From: Gary Bottwood [REDACTED]
Sent: 17 May 2021 09:34
To: Finlay Gardner <Finlay.Gardner@arun.gov.uk>
Subject: Case Ref - BE/59/21/PL 339 Chichester Road ,Bognor Regis PO21 5AN.

SITE PLAN - SHOWING VISIBILITY SPLAYS
1:500 SCALE (at A3)

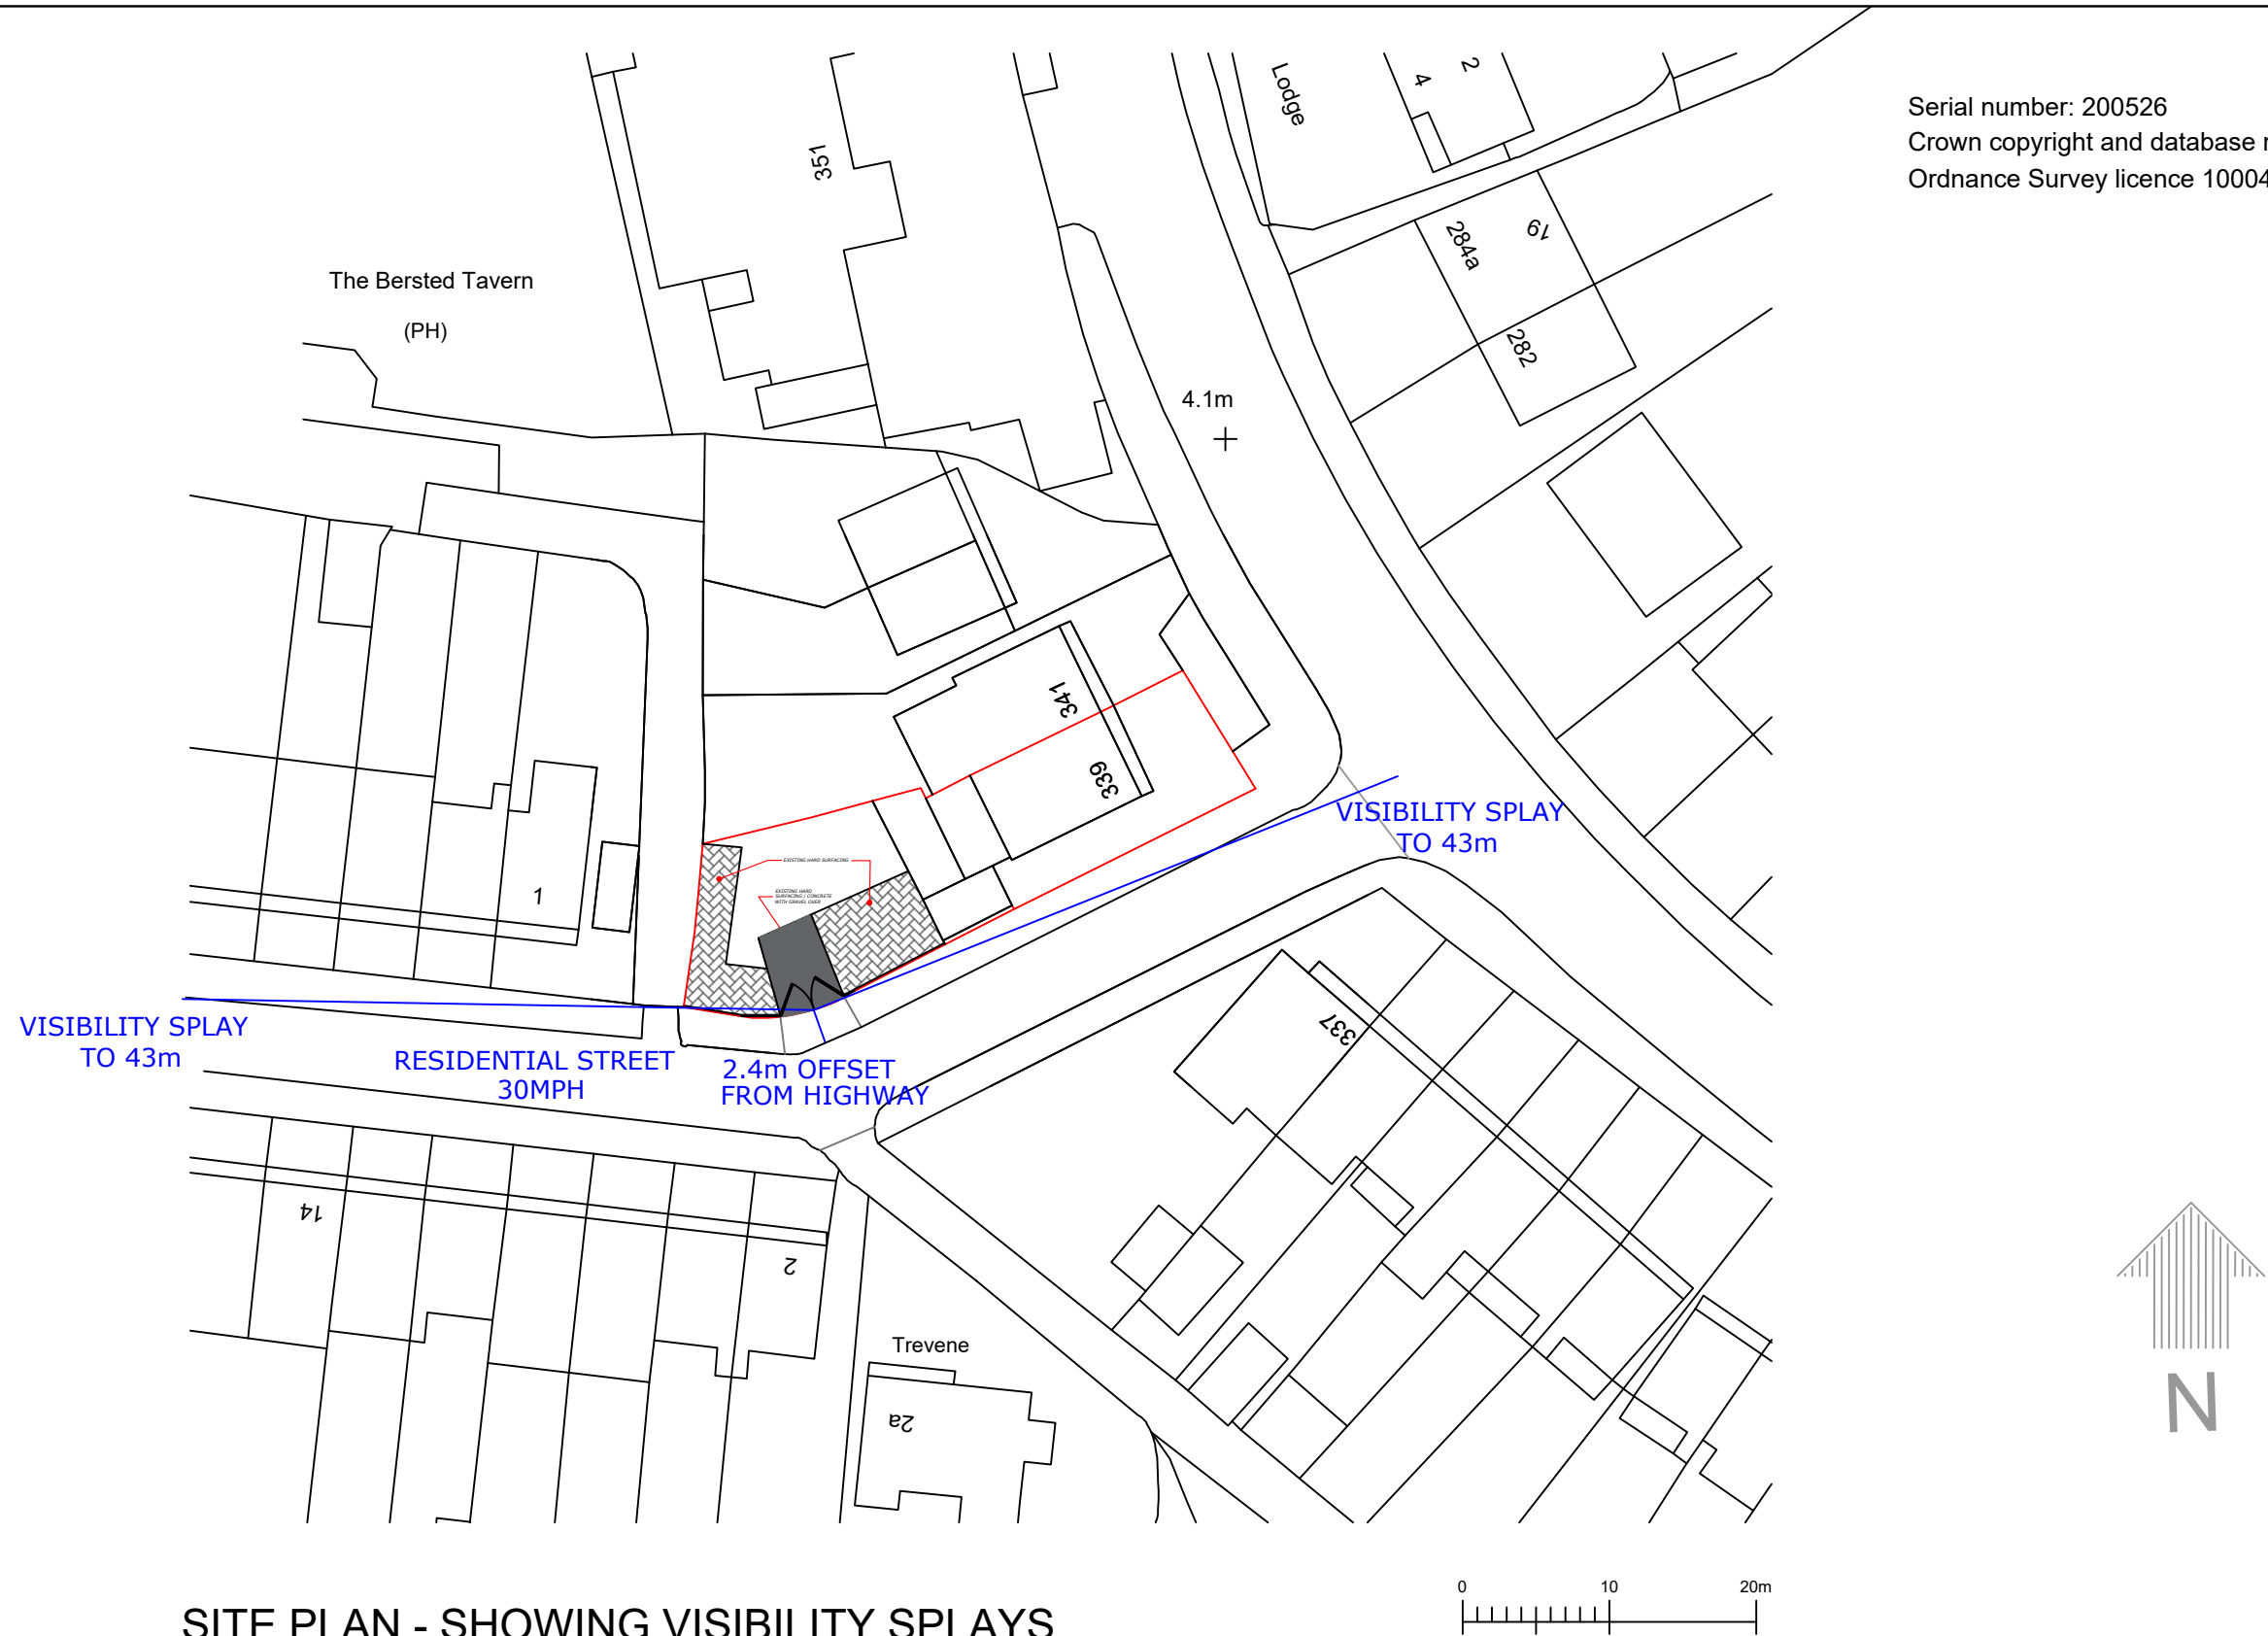
We know you are aware of the site from a previous application you rejected in September 2019 but there are serious issues with the plans and the positioning of the drop kerb being misplaced on the plans. This gives the impression of an improved line of vision for motorists and pedestrians when vehicles are entering or exiting the proposed development. We have measured the distances relative to the plans and found Mr Delaney has 'Slightly adjusted the entrance on the Plans' as his agent advised your colleague was a solution in this Email but has made no mention of moving the Drop Kerb in his application. The agent was apparently advised by Darren Pring at WSCC Highways. The revised plans have the drop kerb on the plans at least 2.5 Mtrs out of position and moving the Drop kerb to correspond with the plans would mean it would straddle the Apex of the bend. This would improve the Visibility but far from solving it as you would need to consider the residents parked cars that would impair visibility crucially to at least a quarter of the 43mtrs required in both directions.
